Our Ref: PAA/38/18/

Pre-Application Advice

Side extension with room in roof
9 Park Drive Rustington

203 Proposed East Elevation

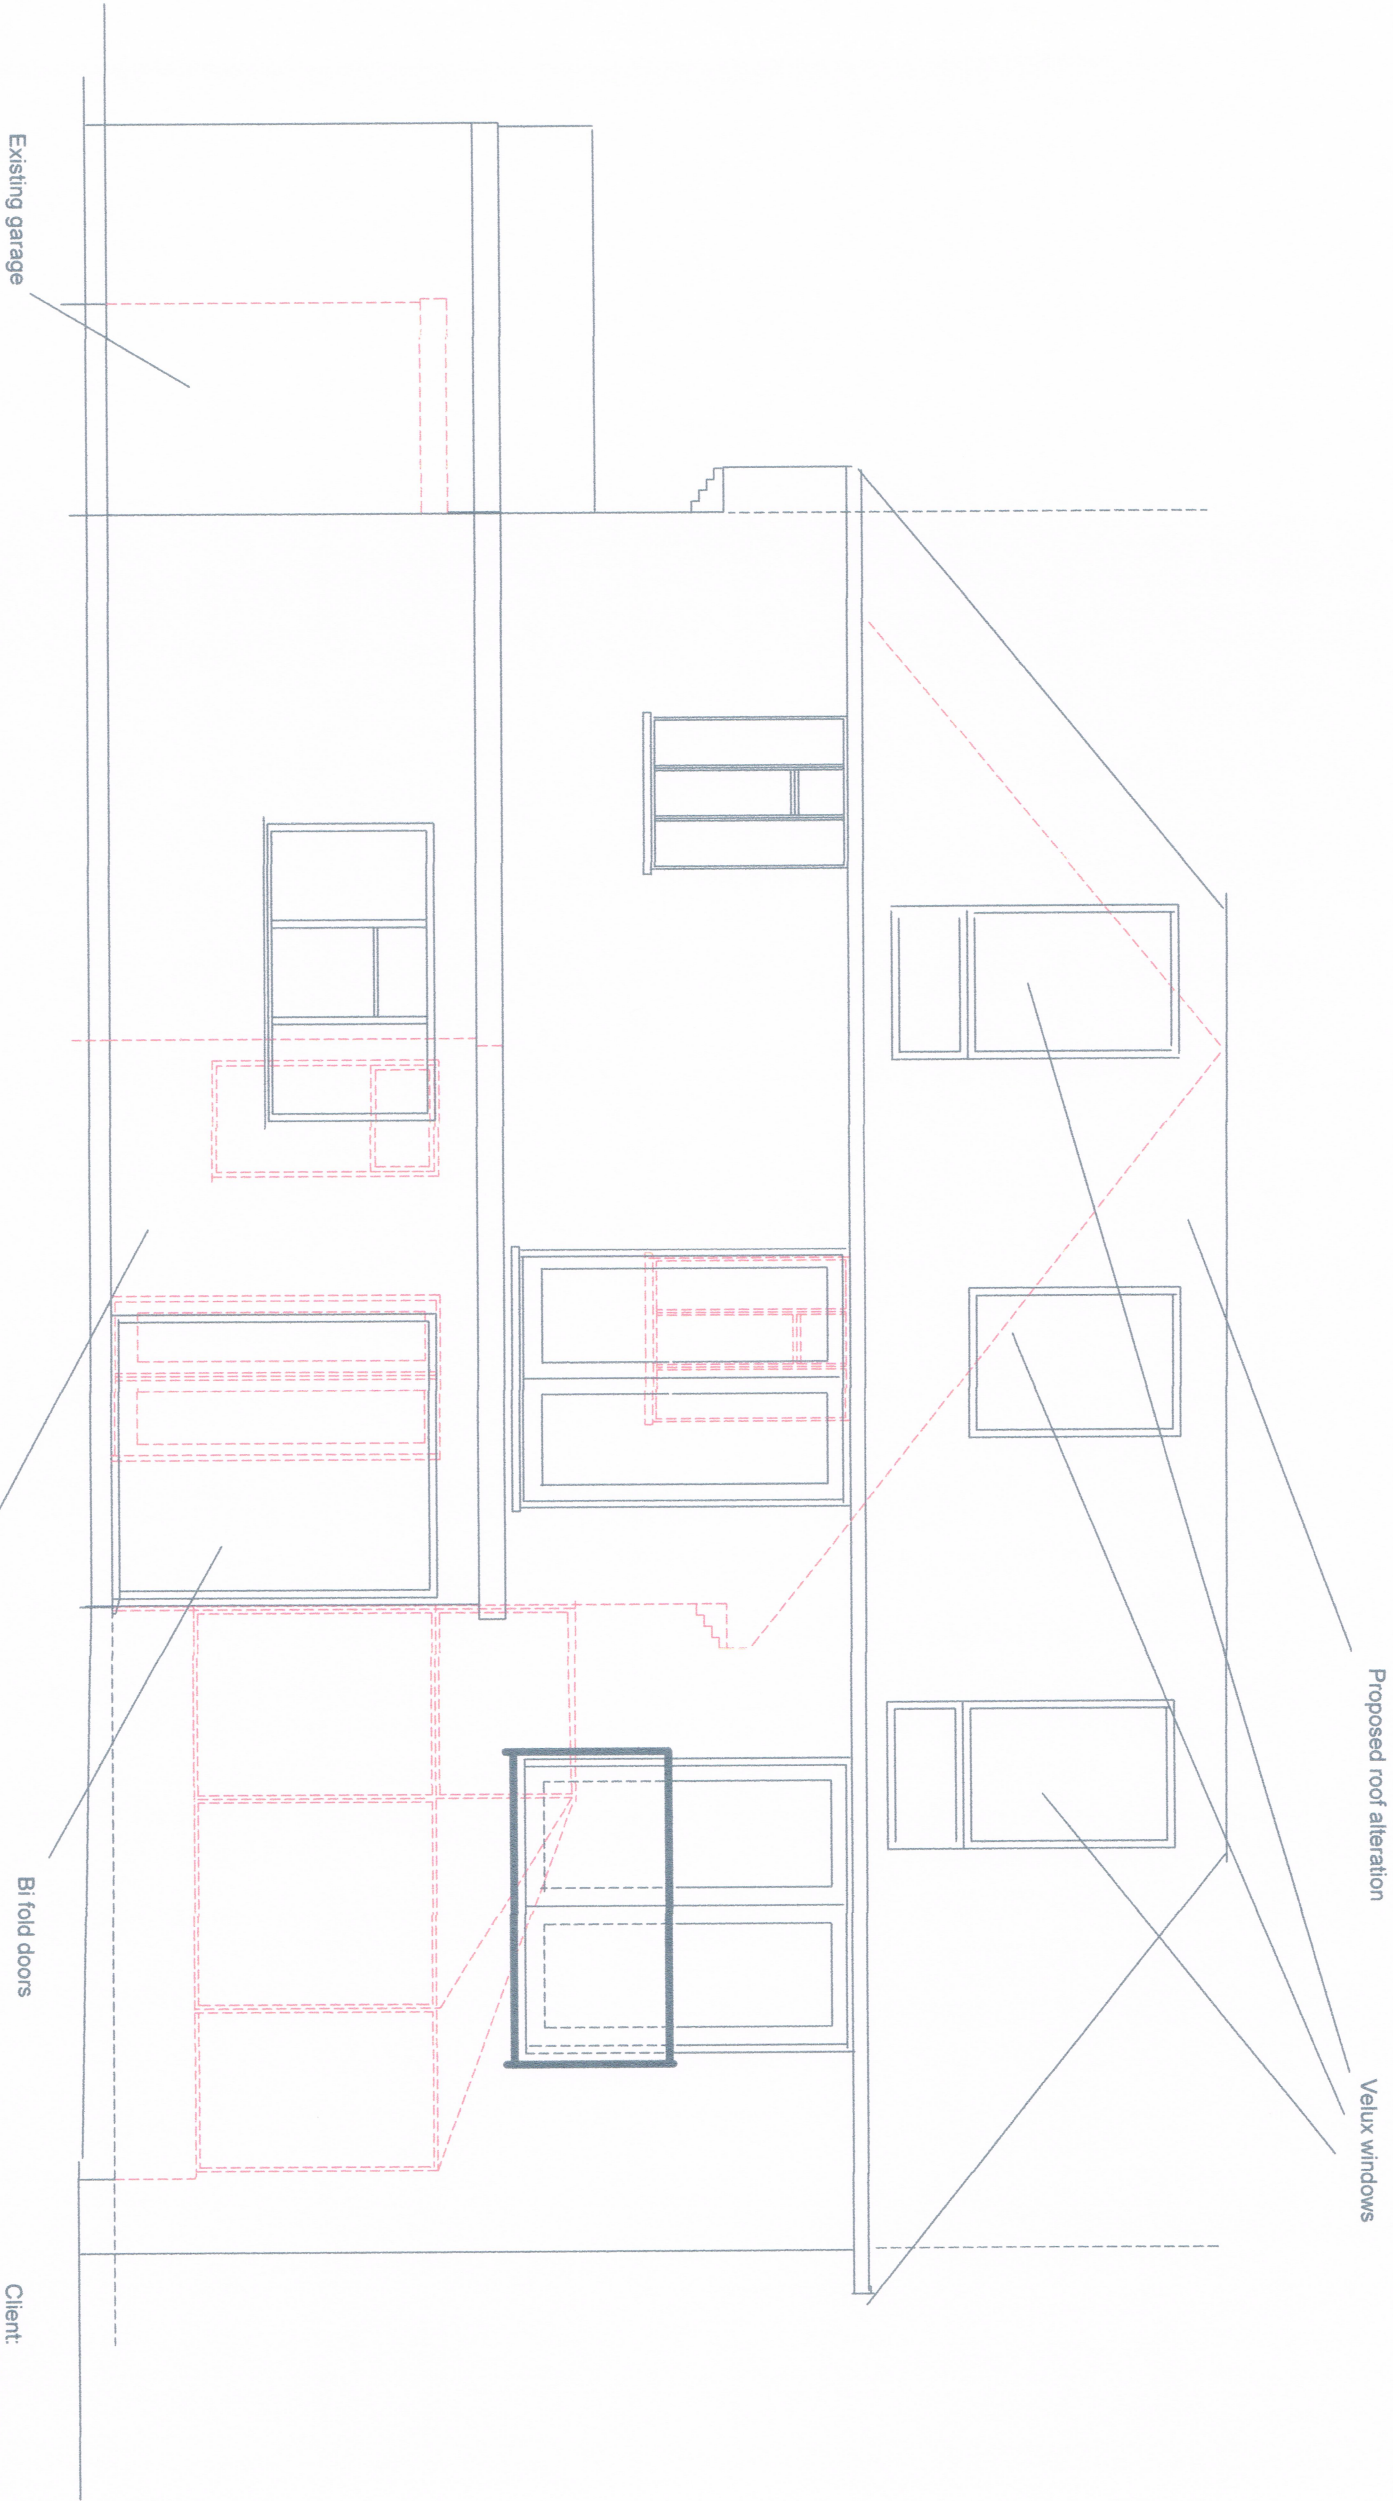
The proposal is a significant extension of the existing dwellinghouse increasing the height and the area of roof facing the street frontage.

The proposal would not be subservient to the existing dwellinghouse and there are no properties along the street with a similar frontage and height across the width of the roofline such that the property would be out of character within the existing street scene.

The applicant may wish to consider reducing the overall bulk of the roof by fully hipping the roof and by setting the two storey extension back from the front elevation with a rear elevation in line

with the location shown on the plans of the back elevation of the balcony.

Proposed West Elevation

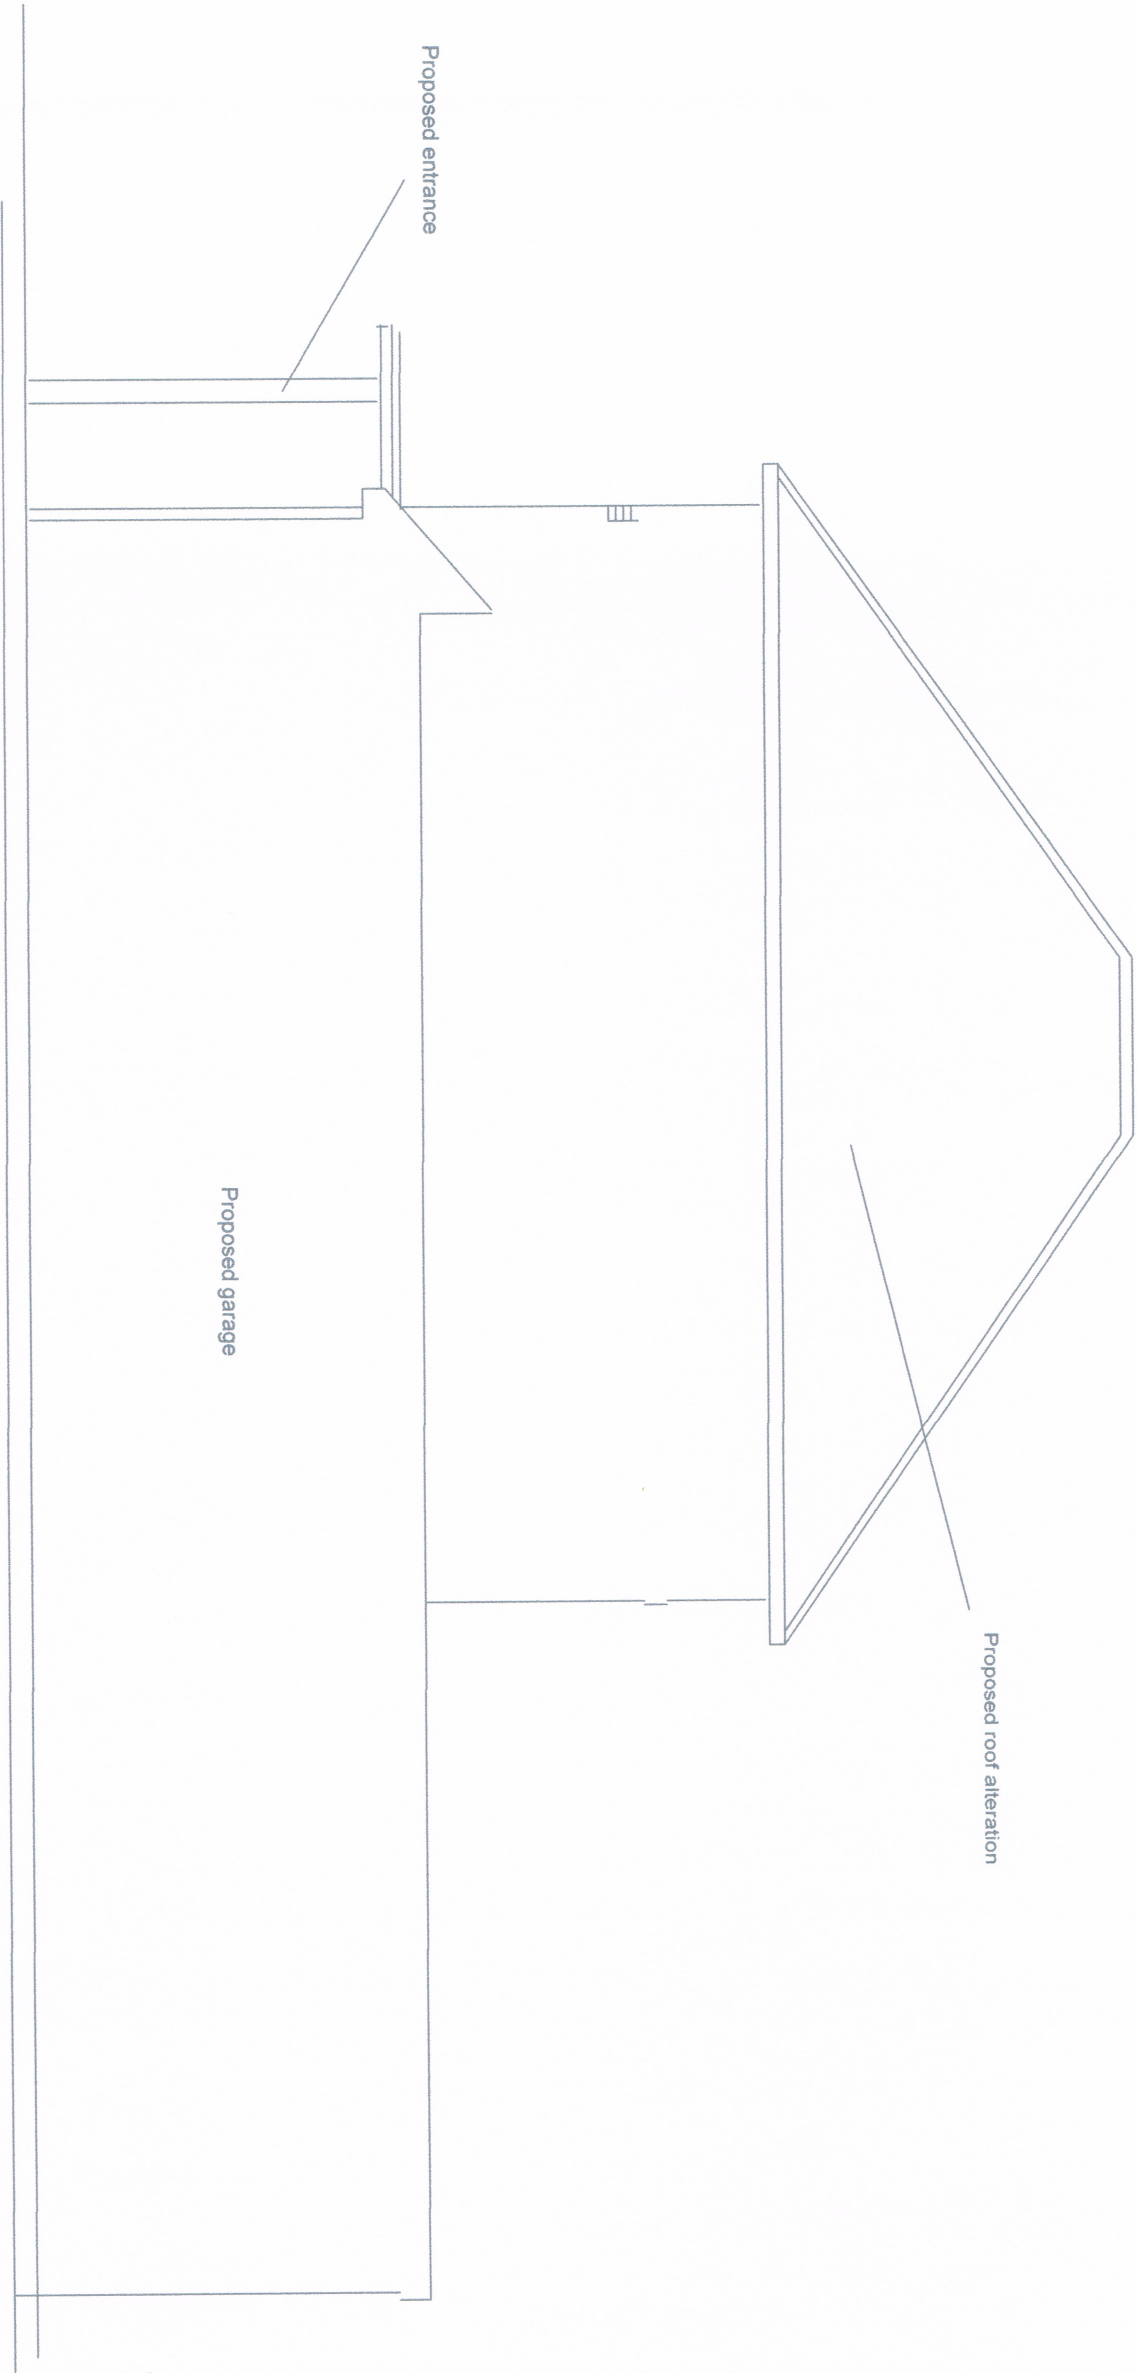
The proposal is not considered to adversely affect the primary habitable room windows of neighbouring properties and would not cause unacceptable overlooking, overbearing impact or loss of light subject to a condition that the balcony was screened at the sides with a 1.8 metre obscure glazed panels.

There is a particular concern that without a 1.8 metre privacy screen on the sides of the balcony that overlooking and loss of privacy would impact significantly on the flats at Herne Court immediately to the south.
